DECISION DELEGATED TO DEVELOPMENT MANAGER

Application No:	H02-1090-19	Applicant:	Cross Keys Homes
Proposal:	Residential development - 30 dwellings and associated works - outline approval H02-0054-18		
Location:	18 Low Road Crowland Peterborough		
Terminal Date:	31st May 2021

Drawing Title
Proposed Site Boundary Treatments

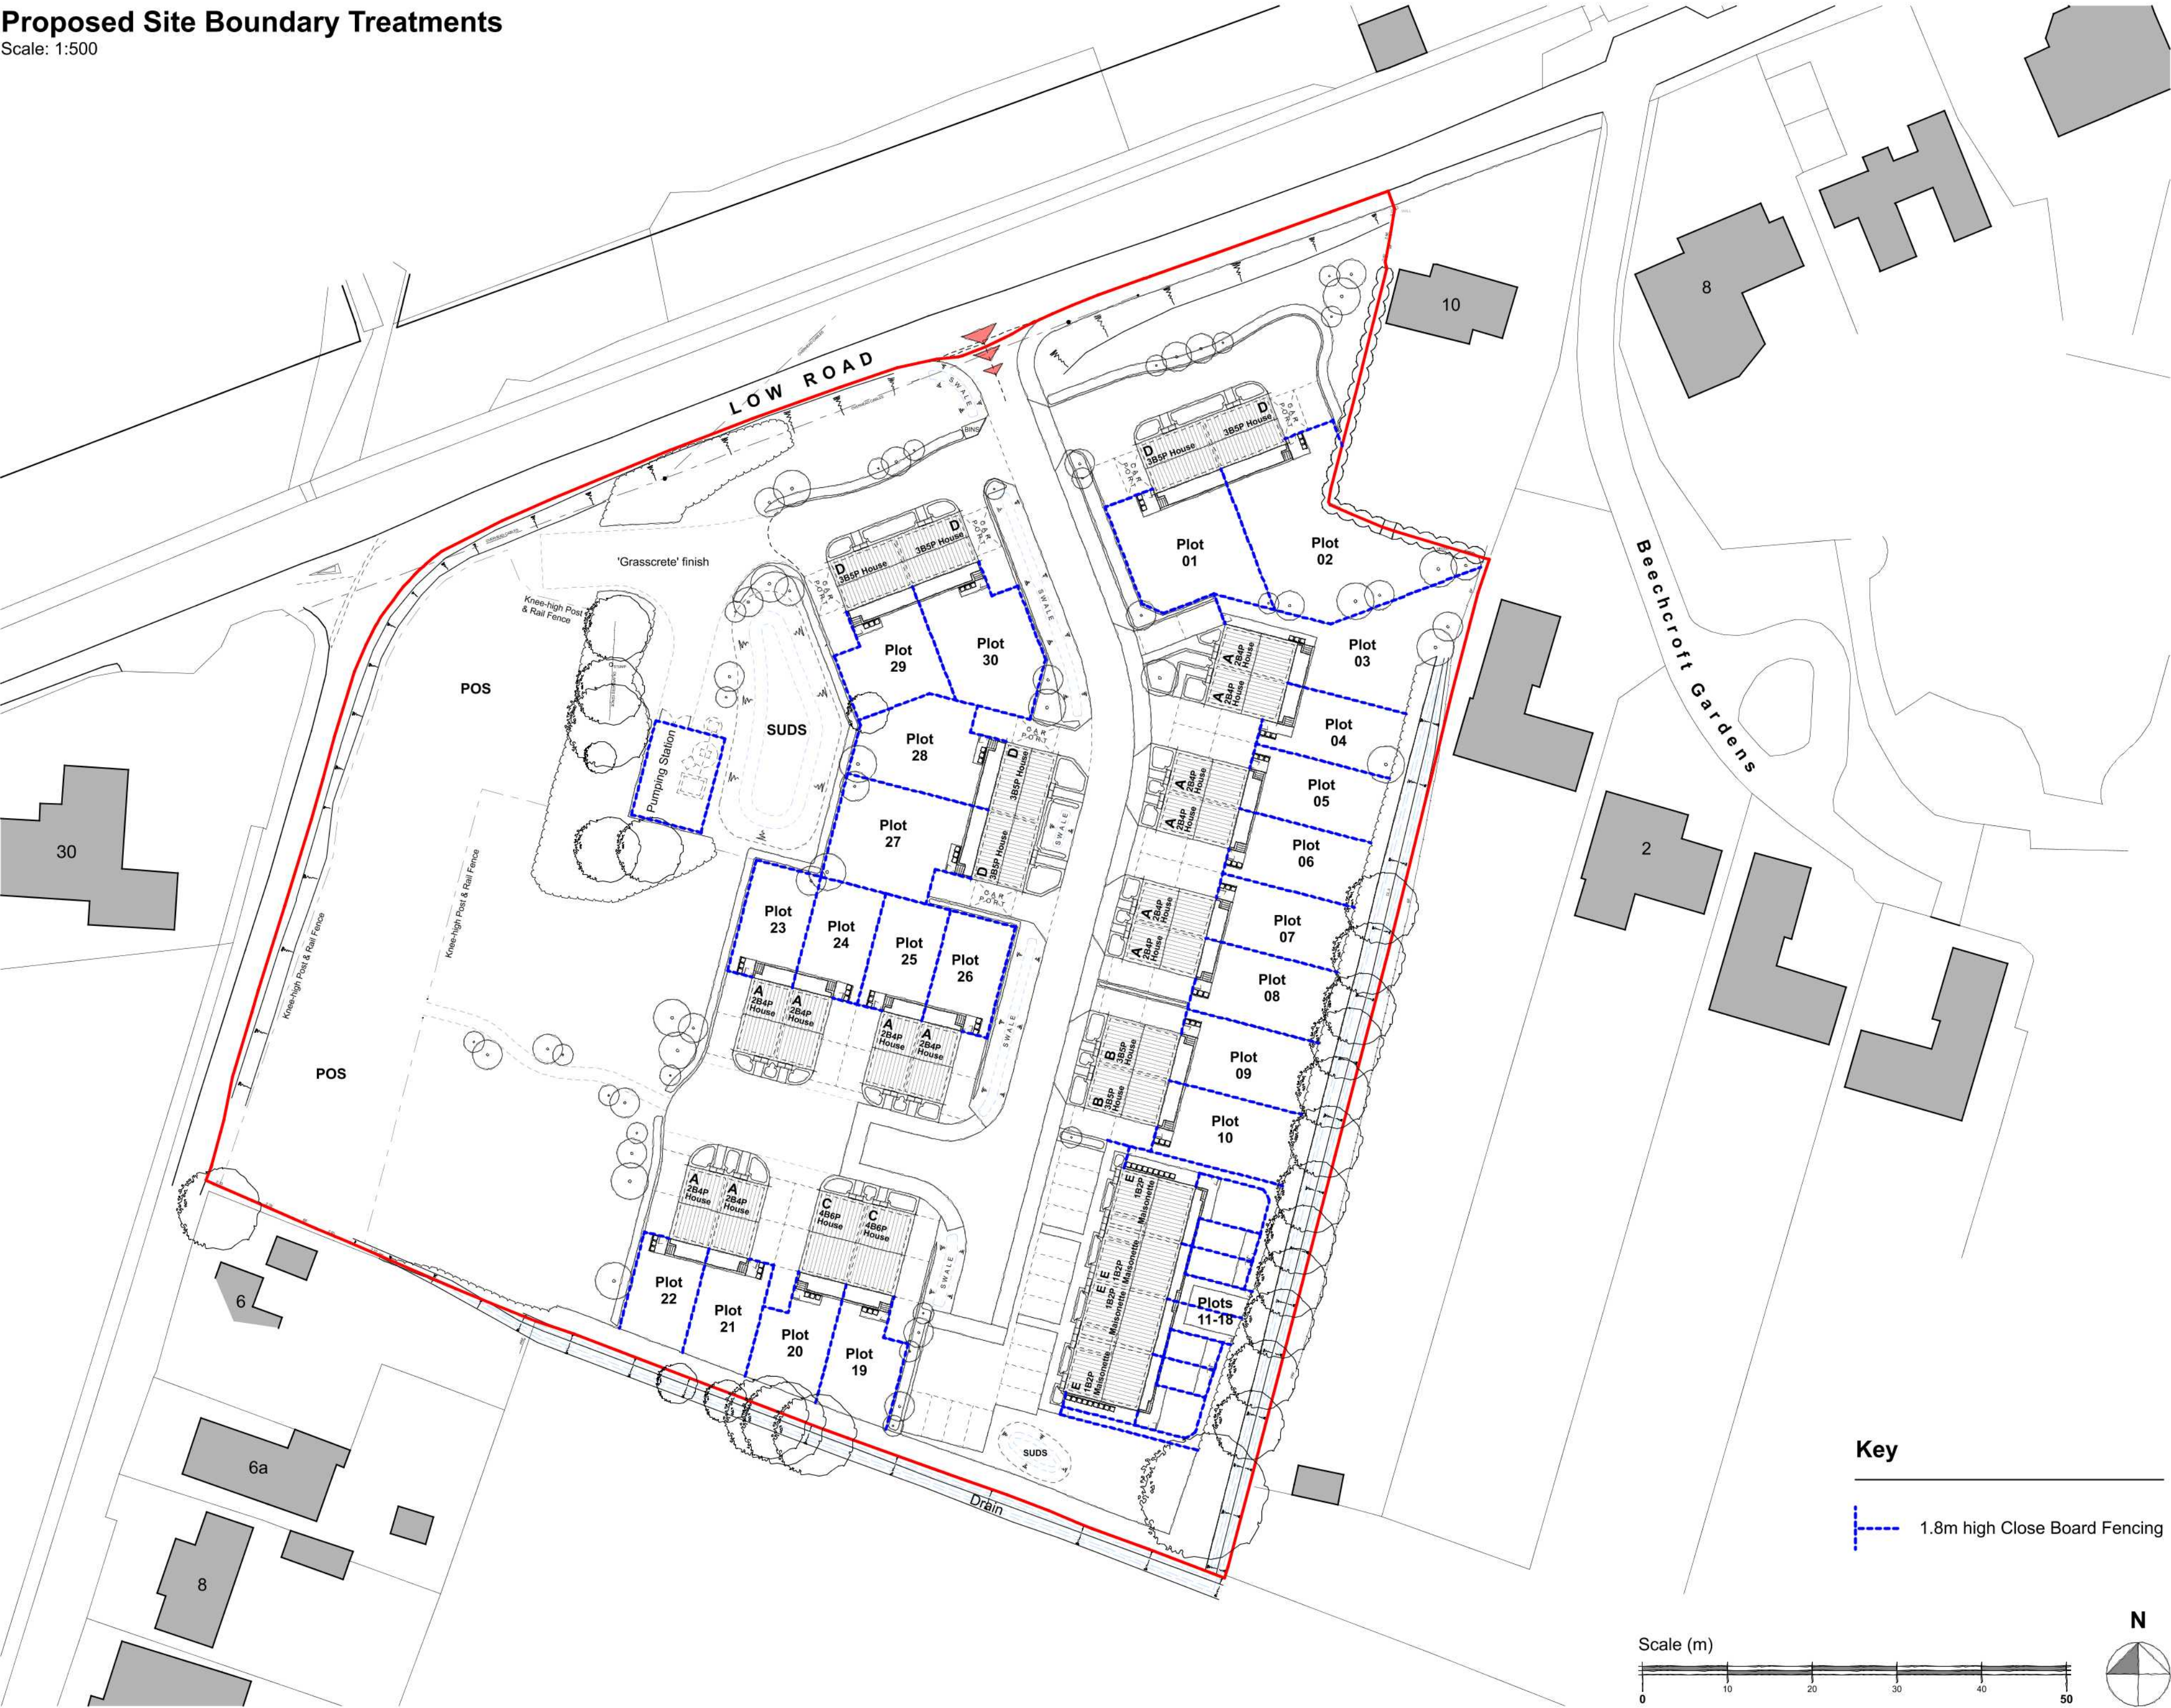
Boundary treatments are also an important element of a landscaping scheme. 1.8m close board fencing is proposed along the southern and eastern boundaries as well as to the rear/in between properties. The fencing to the eastern boundary will be set in to allow for maintenance of the drain on that side. This drain is riparian and will therefore be the joint responsibility of adjoining landowners. Planting will be provided in prominent locations to soften the impact of fencing. Higher fencing will be provided to the east of Plot 2 where the patio is to be raised and thus there would be the potential for overlooking the rear garden of 10 Low Road.

Concern has been raised regarding the positioning of the fencing to the rear of Plots 2 and 3 and it was asked whether this could be moved in line with the remainder of the fencing for Plots 4 to 10. However, the applicant has declined to reposition the fencing due to the loss of garden land this would entail for both plots and where there is no need to allow a buffer for maintenance of the drain. New fencing to rear gardens is frequently sited adjacent existing fencing in new developments. Furthermore, the facing windows to 1 Beechcroft Gardens are to a kitchen and utility space, which are not deemed to be habitable spaces in planning terms. It is therefore not considered that this would represent a material issue what would justify withholding permission.
